Y/89/20/L

Hobbs Court, Dovecote Bilsham Road Yapton BN18 0JY

Listed building consent for a new window in existing external wall.

PROPOSED PART FLOOR PLAN 1:100

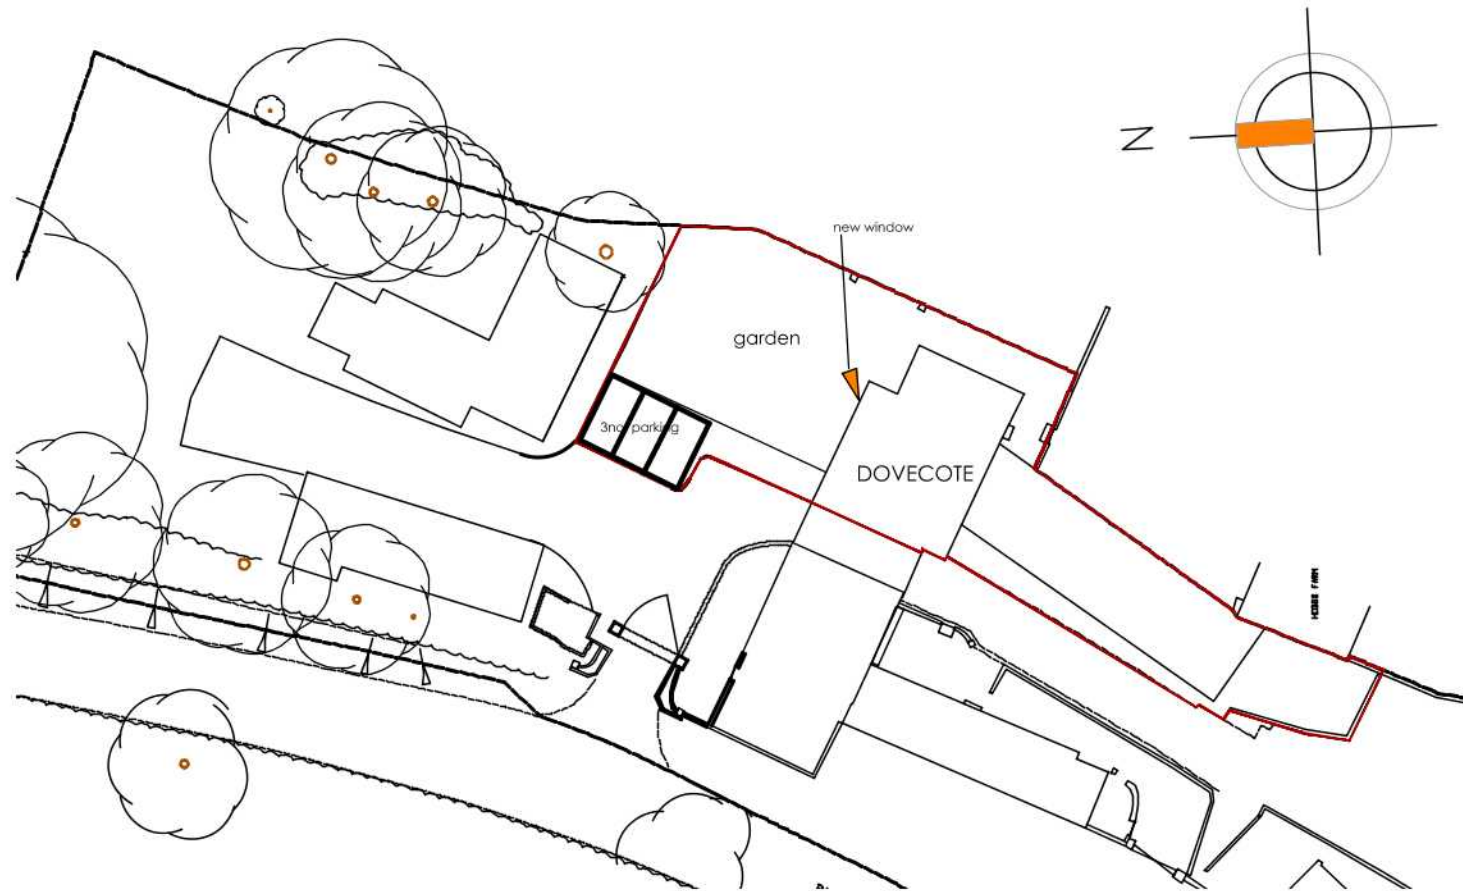
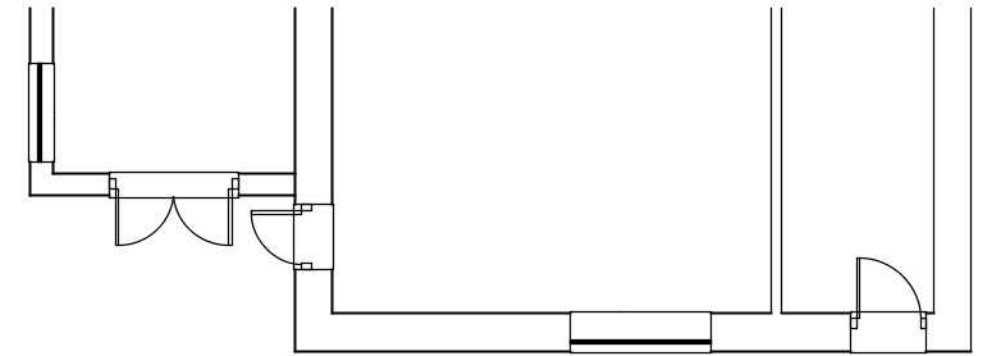
The proposal is for the introduction of an additional window on the north-east elevation which will provide more light into the ground floor space. It is noted that the applicant states that the window will replicate the existing one immediately to its right. The neighbouring window is of an appropriate design, and its replication is considered to be acceptable. Also noted and supported are the references to the proposed lintol and facing brick work. Materials should match those existing, and any flints that are removed as part of the opening could be retained on site for other works of repair to the listed building.
